DRB CASE ACTION LOG

DRB Application No.: 03-01037 (P&F)
Project Name: Clayton Heights Subdivision
Agent: Harris Surveying

**CITY OF ALBUQUERQUE
PLANNING DEPARTMENT
Development Review Board Comments
July 9, 2003**

RE: Clayton Heights Subdivision

**PLAT OF
LOTS 3-A AND 4-A, BLOCK 5
CLAYTON HEIGHTS SUBDIVISION**

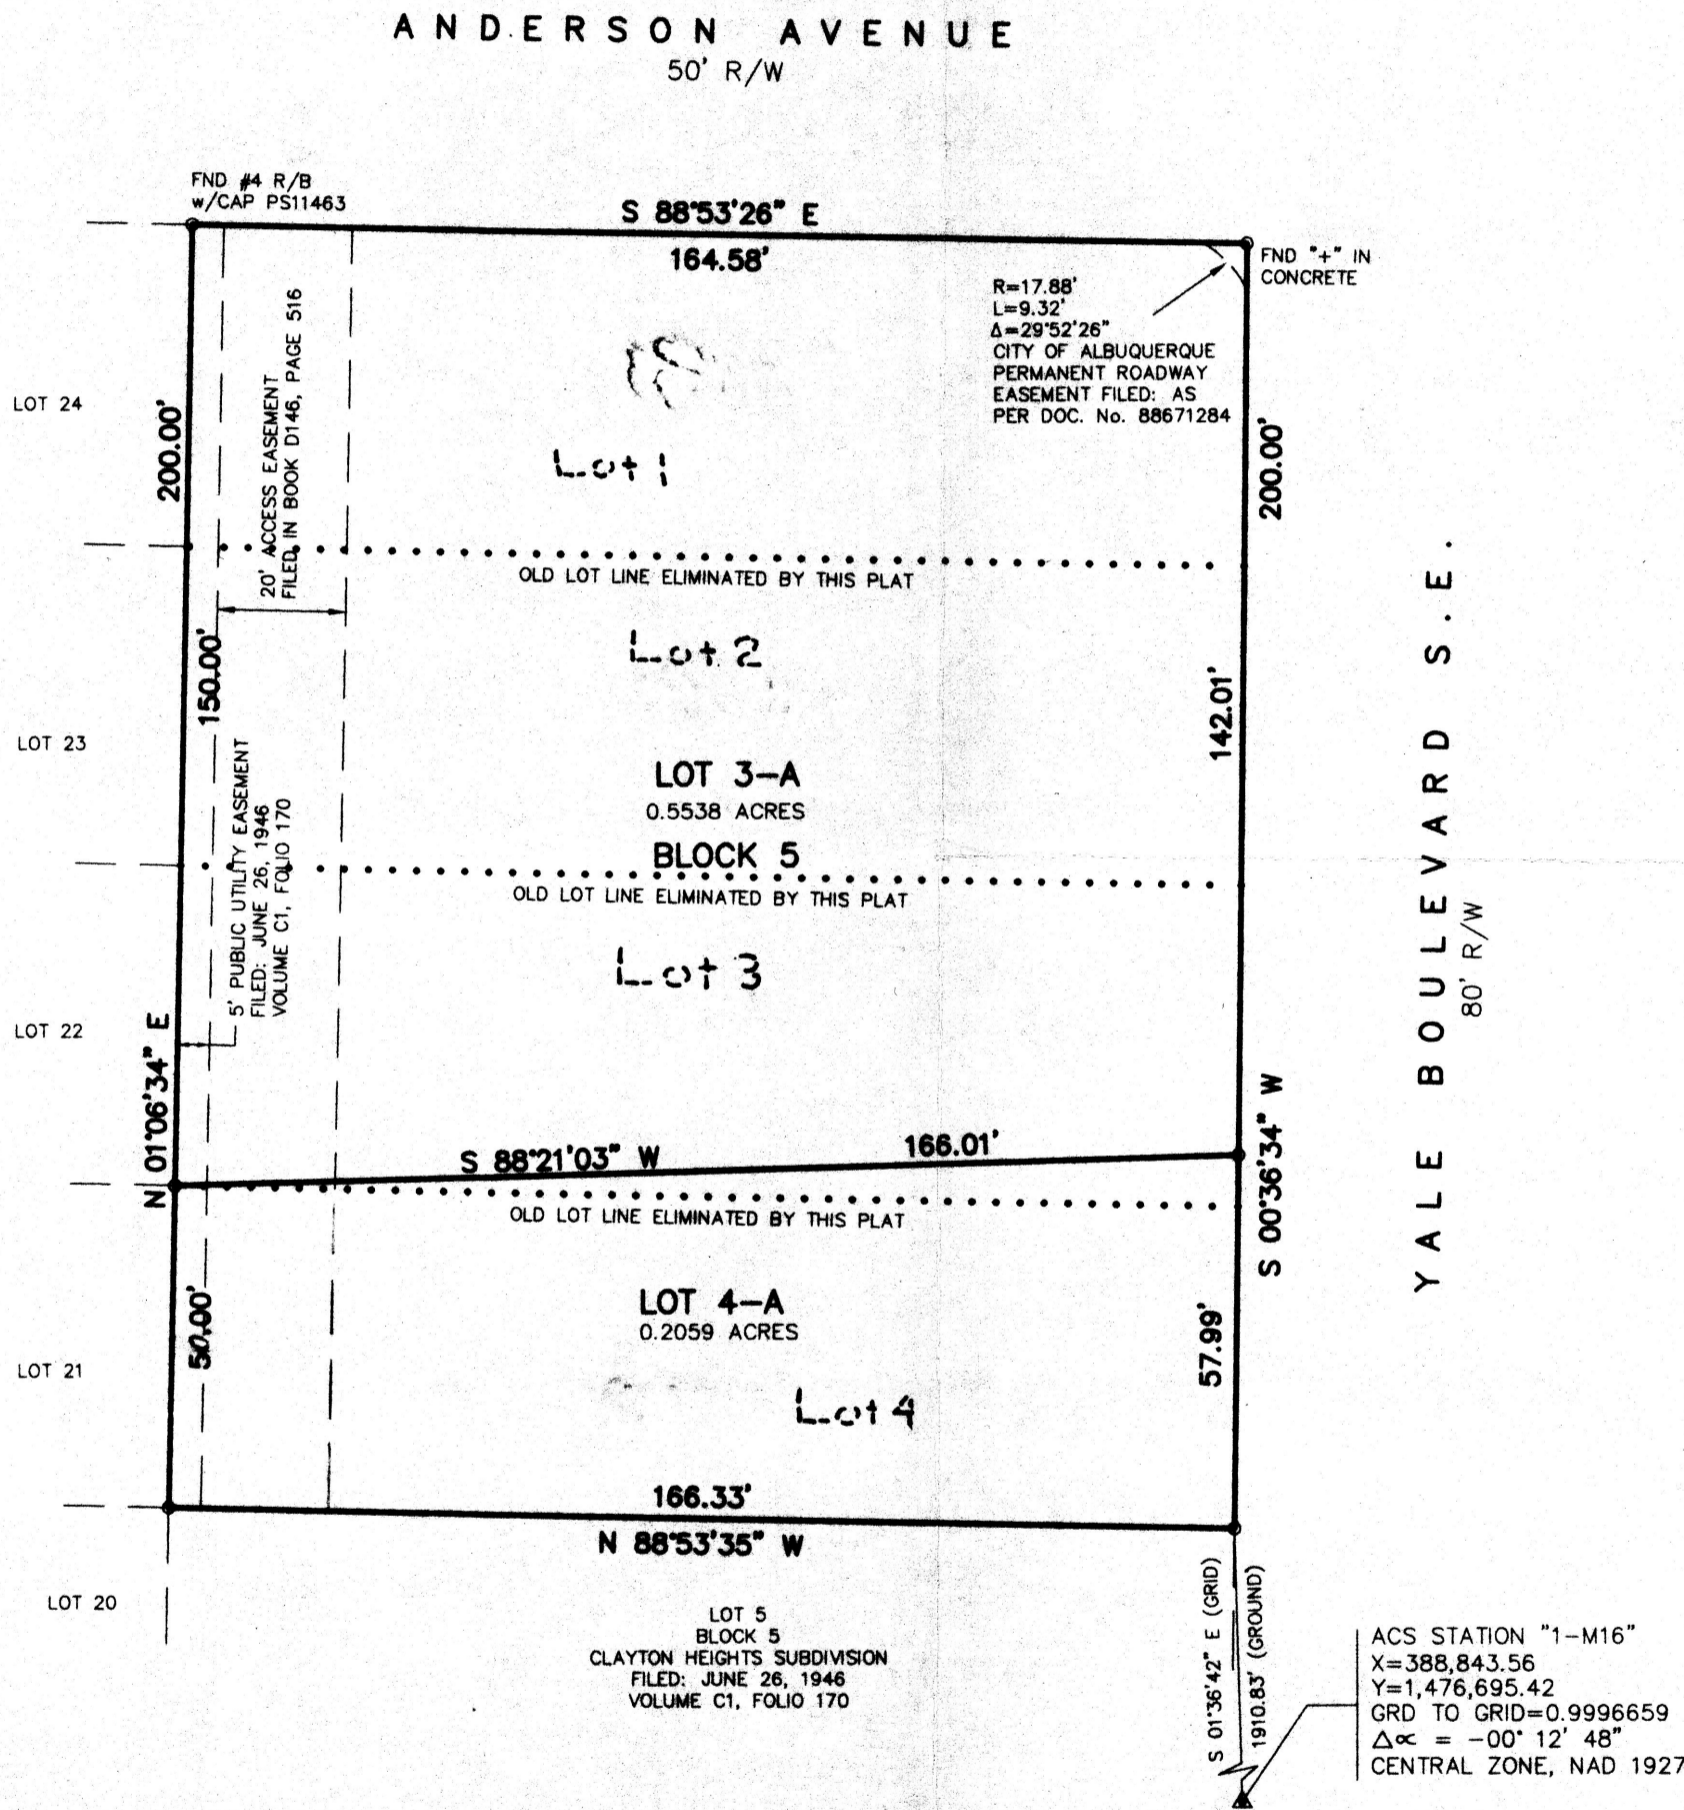
TRANSPORTATION: 43' From center of YALE is req'd, along w/20' RADIUS.

No.	Comment
<input type="checkbox"/>	Right-of-way dedication is needed, 43ft from the center of Yale and 20ft radius at intersection.
